Our Ref: TR040011

Application by North Somerset District Council for an Order Granting Development Consent for the Portishead Branch Line – MetroWest Phase 1

Advice following issue of decision to accept the application for Examination

2.3 - Works Plan

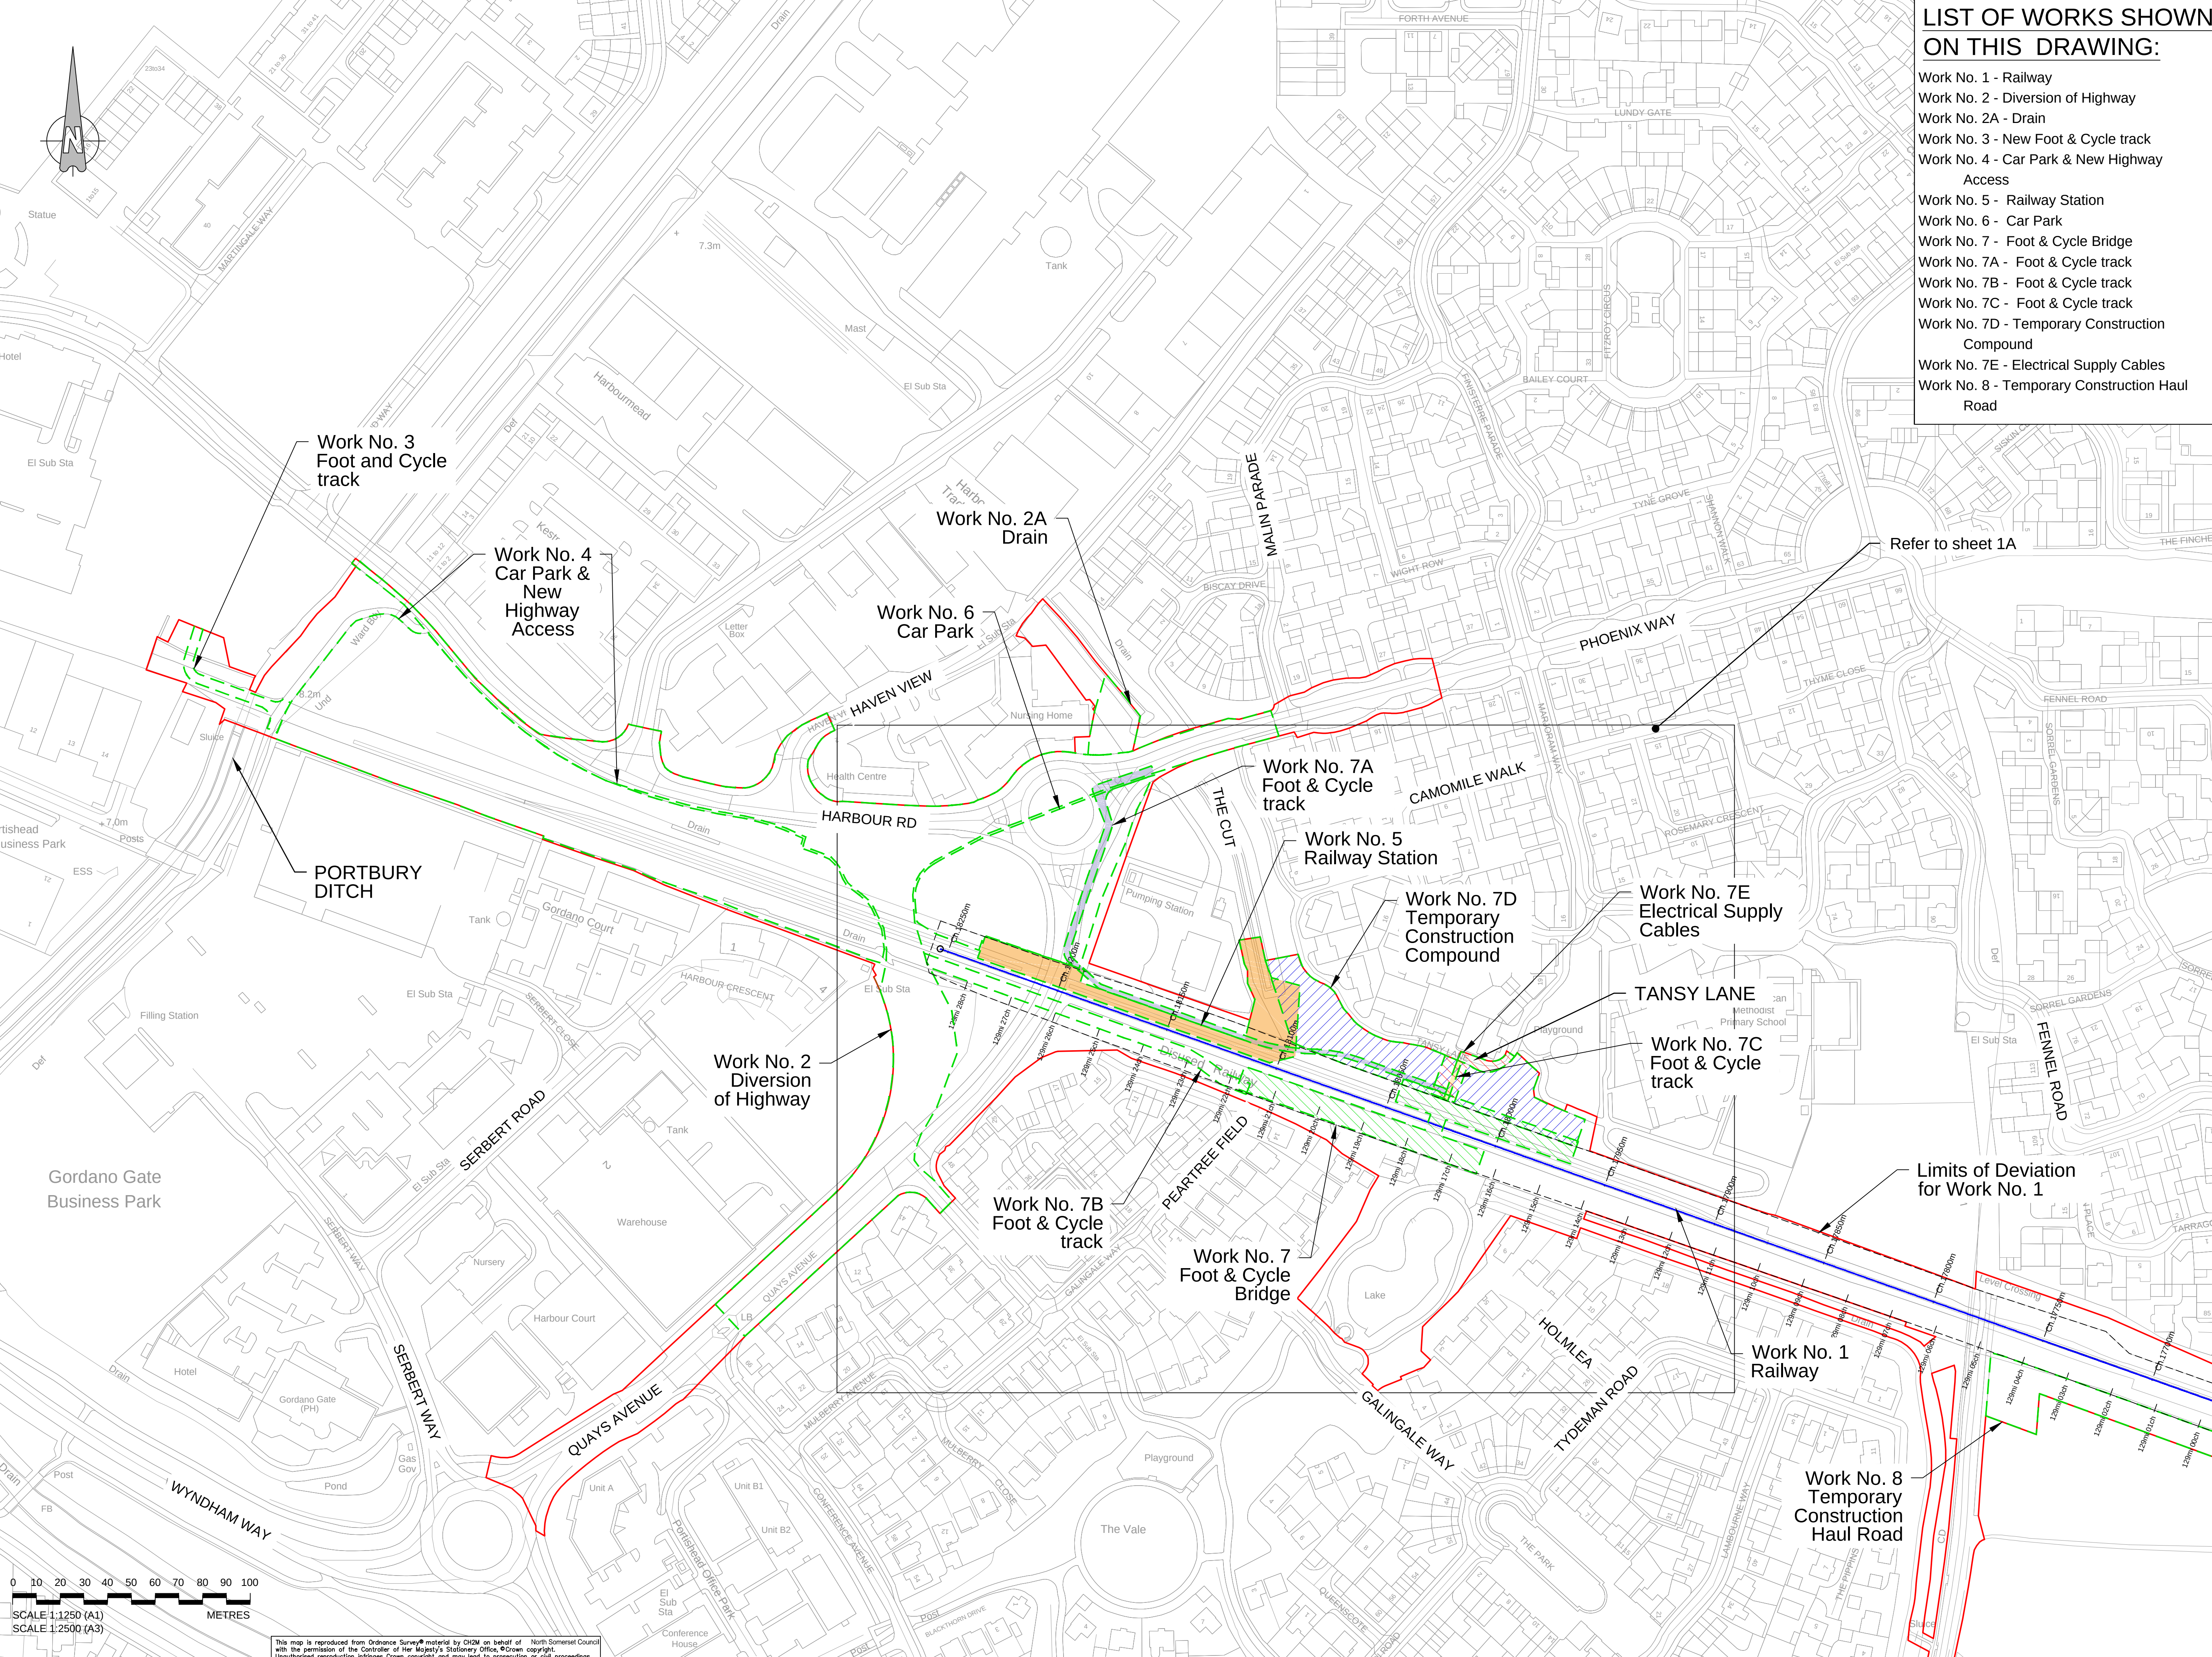
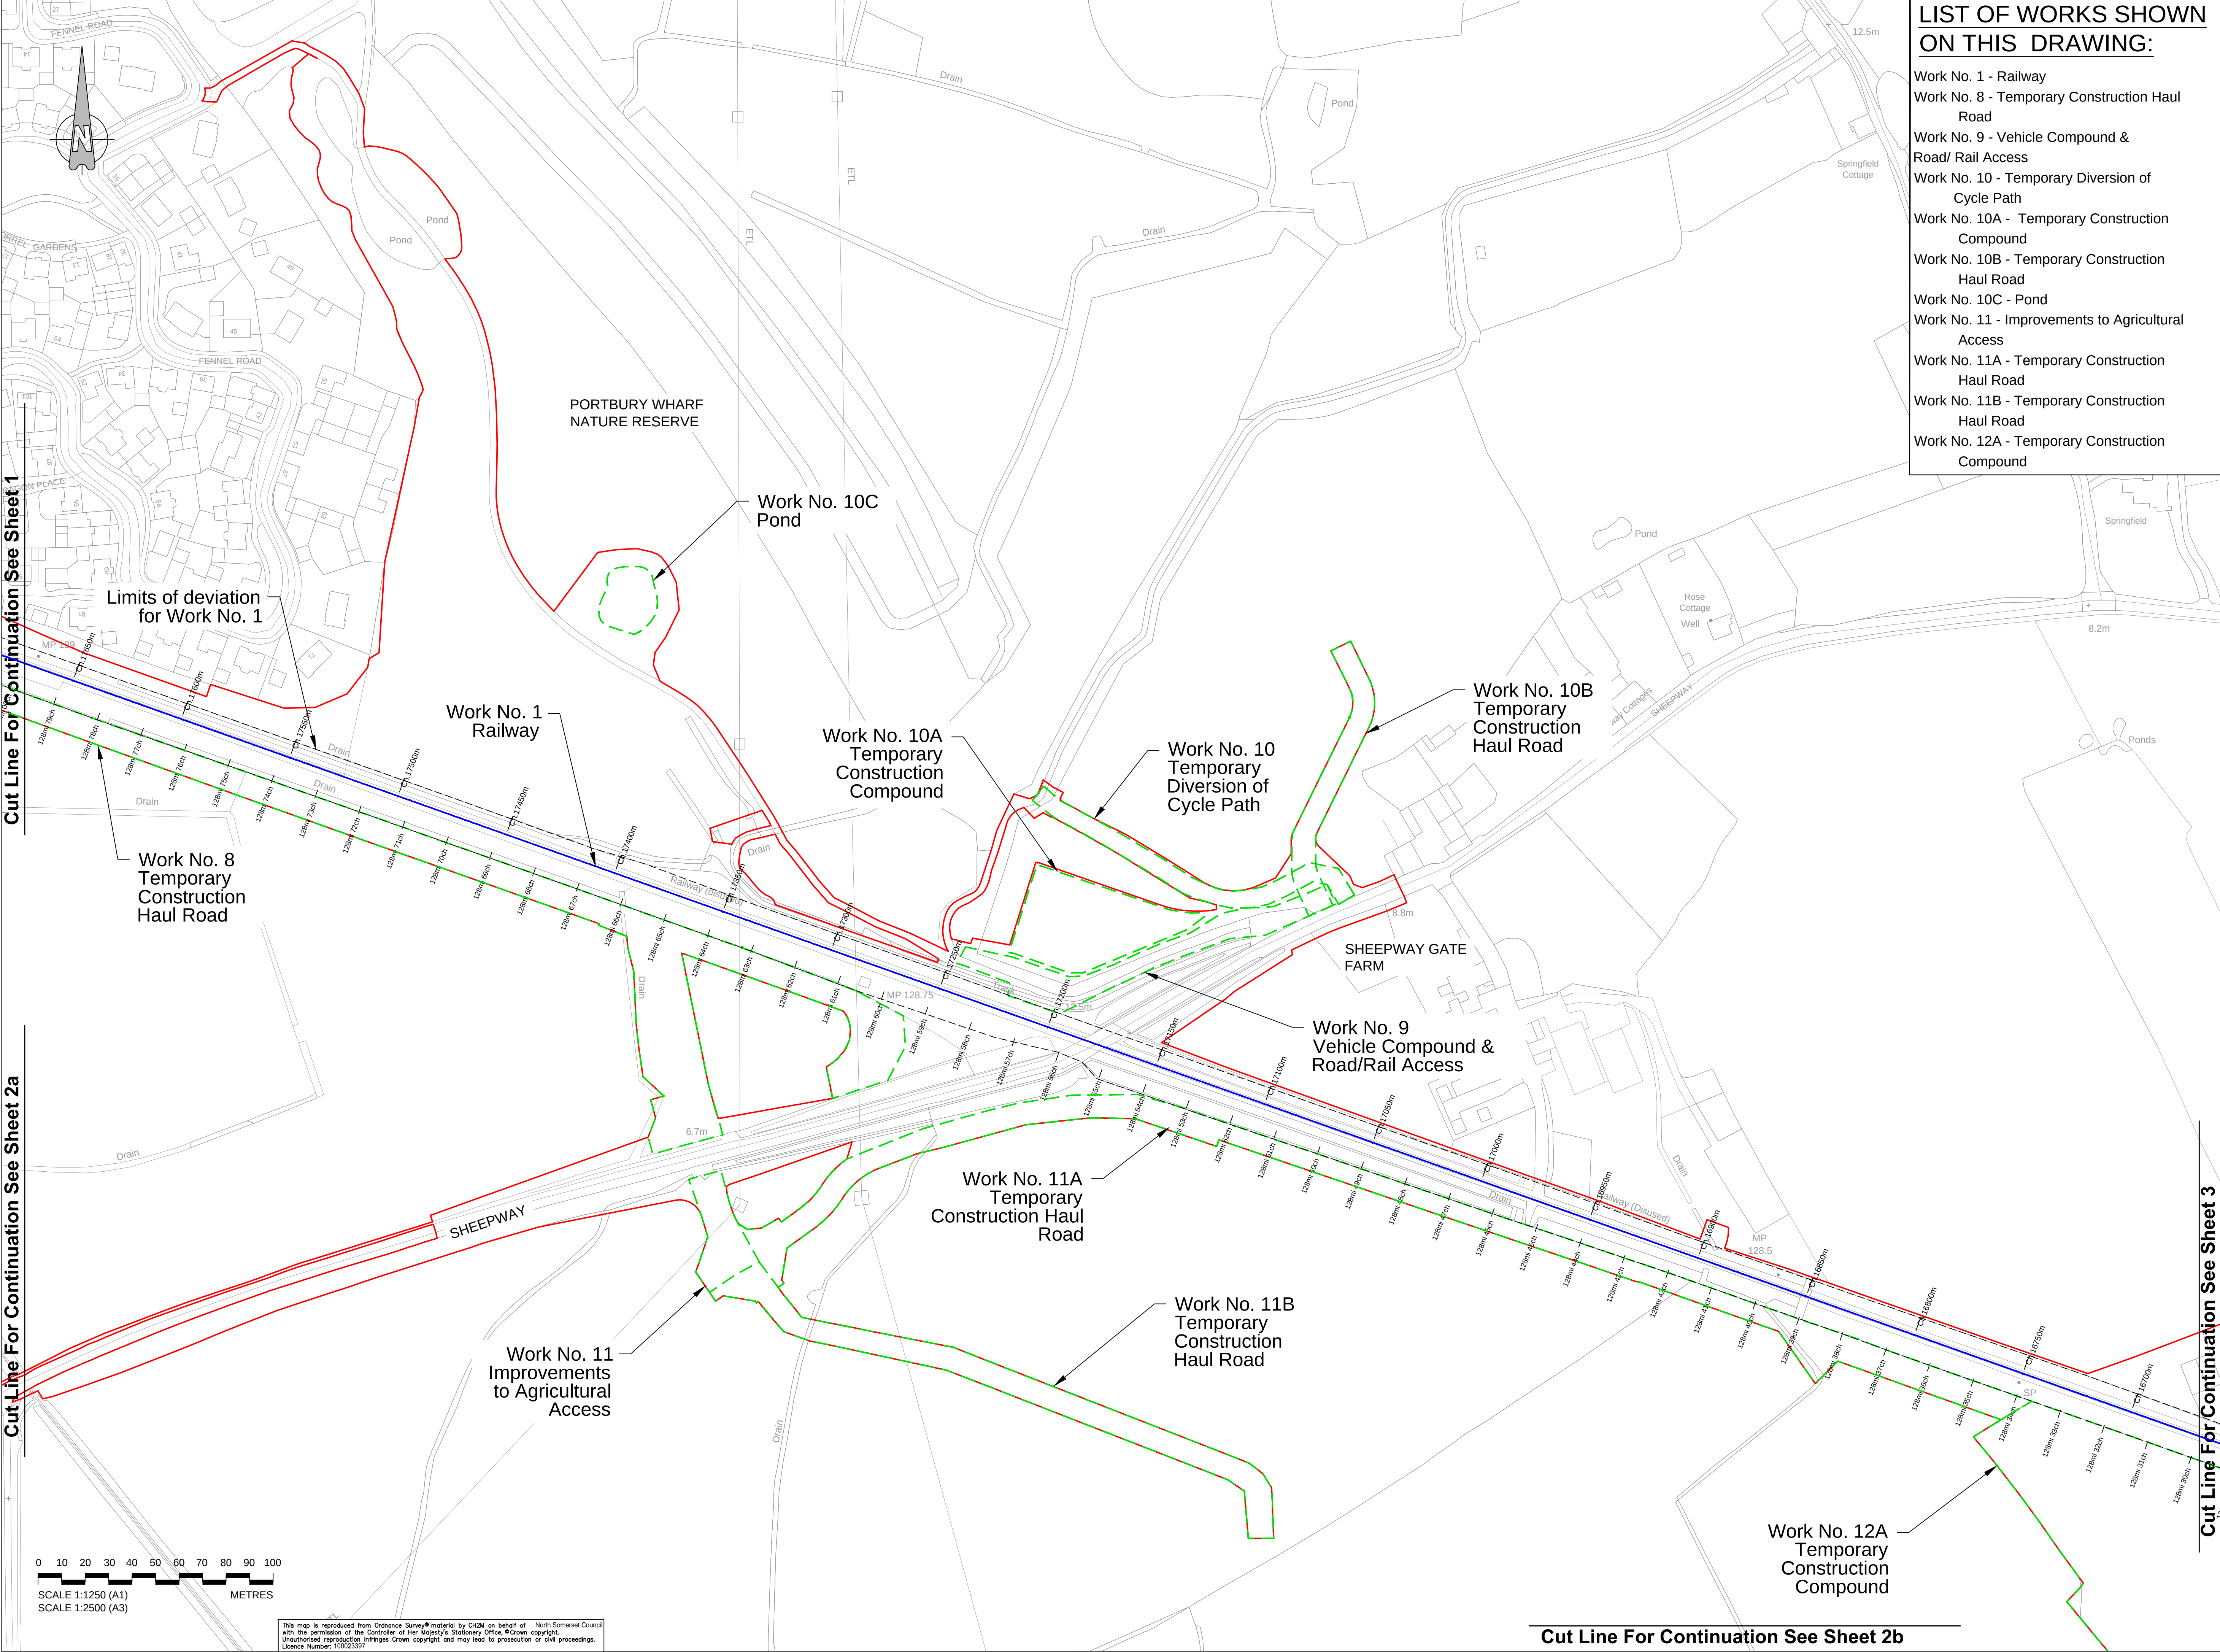
There are also inconsistencies between the Description of the Works in Schedule 1 of the draft Development Consent Order and the Works Plans (**Doc 2.3**) (eg Works Plan 2a, 7e, 13a).

The Applicant is advised to carry out a comprehensive check of these documents to ensure all information provided is complete and accurate and provide updated documents, if required.
